# 2019 Financial Assurance Estimate Form (with pre-plat construction)

PROJECT INFORMATION			
The Trails at Aspen Ridge Filing No. 2	4/15/2020	\$ 389,310.00	SF1927
Project Name	Date		PCD File No.

DESIGNED BY: NMS	SCALE	DATE ISSUED: FEBRUARY, 2020	DRAWING No. RD02
DRAWN BY: CRD	HORIZ. 1" = 40'	SHEET 5 OF 36	
CHECKED BY: NMS	VERT. 1" = 8'

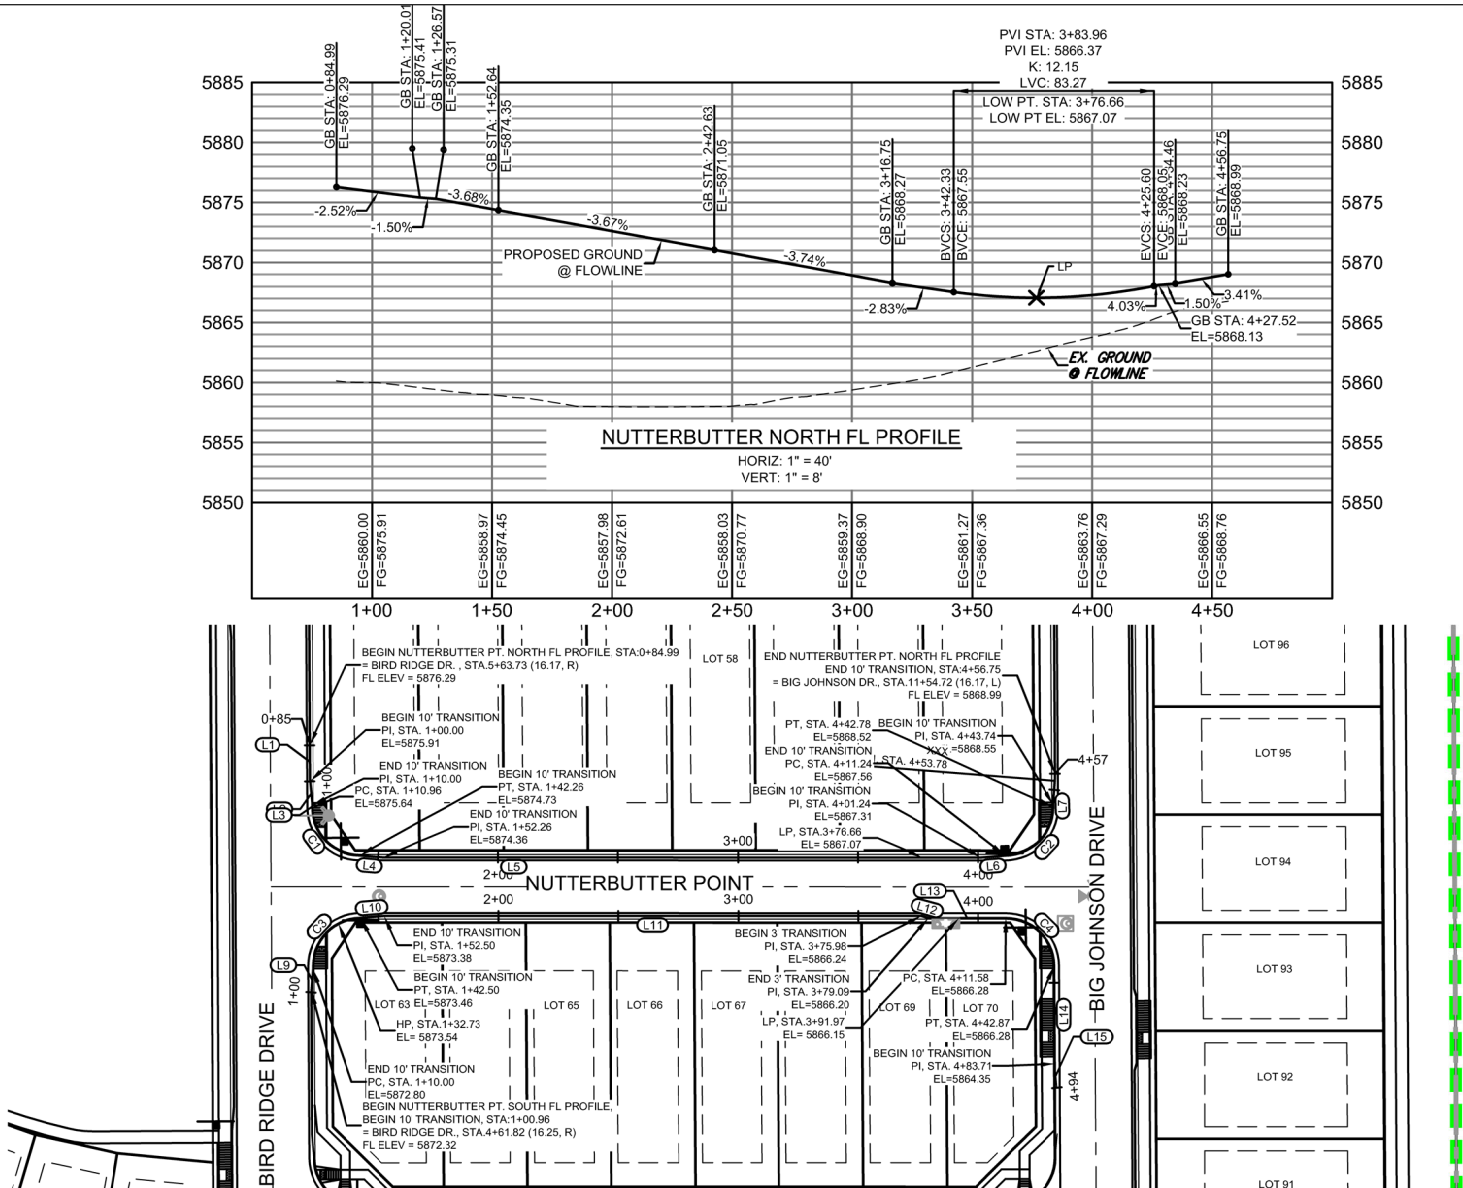
The construction drawings show 4" sidewalk in front of open space. Update the 4" and 5" thick sidewalk per redline comments on the construction drawings (sheet 3 of 36).
